WEST SUSSEX COUNTY COUNCIL CONSULTATION

TO:	Arun District Council FAO: Hannah Kersley
FROM:	WSCC – Highways Authority
DATE:	14 November 2024
LOCATION:	47 Aldwick Road, Bognor Regis, PO21 2NJ
SUBJECT:	BR/187/24/PL Conversion & Change of Use of Single Storey Former Printers Workshop to Form 2-Bed Dwelling with Cycle Parking & Refuse Storage Facilities. This application is in CIL zone 4 and is CIL liable as a new dwelling.
DATE OF SITE VISIT:	n/a
RECOMMENDATION:	Advice

Proposed Bike and Bin Store

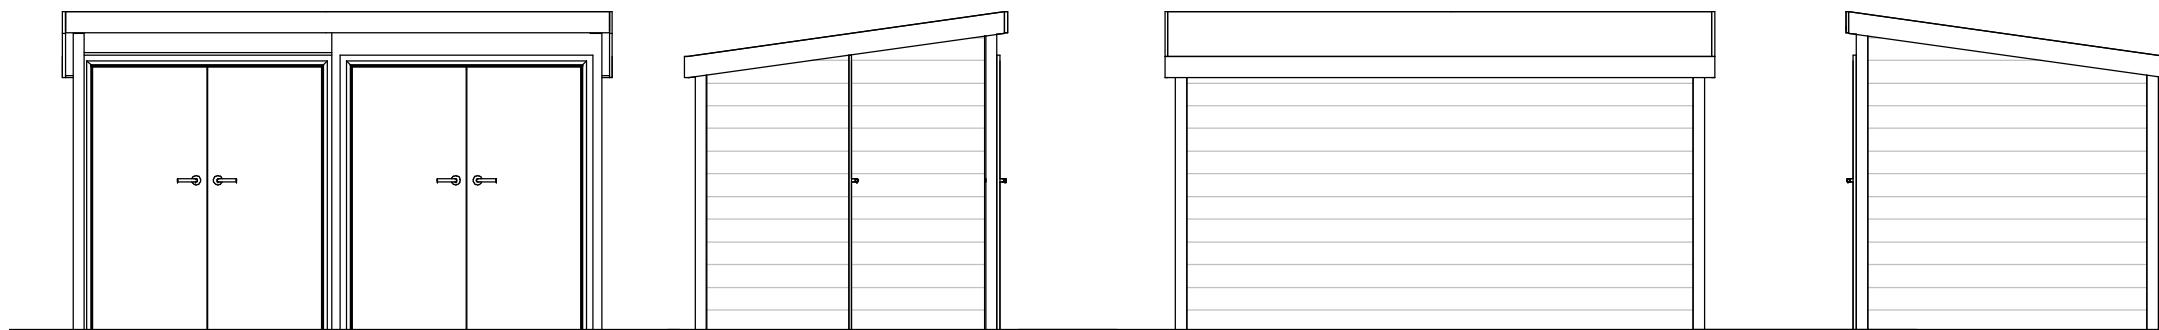
The applicant proposes a cycle store to the rear of the site, which will provide secure cycle parking provision in accordance with WSCC Parking Standards.

No part of the development shall be first occupied until covered and secure cycle parking spaces have been provided in accordance with plans and details to be submitted to and approved by the Local Planning Authority.
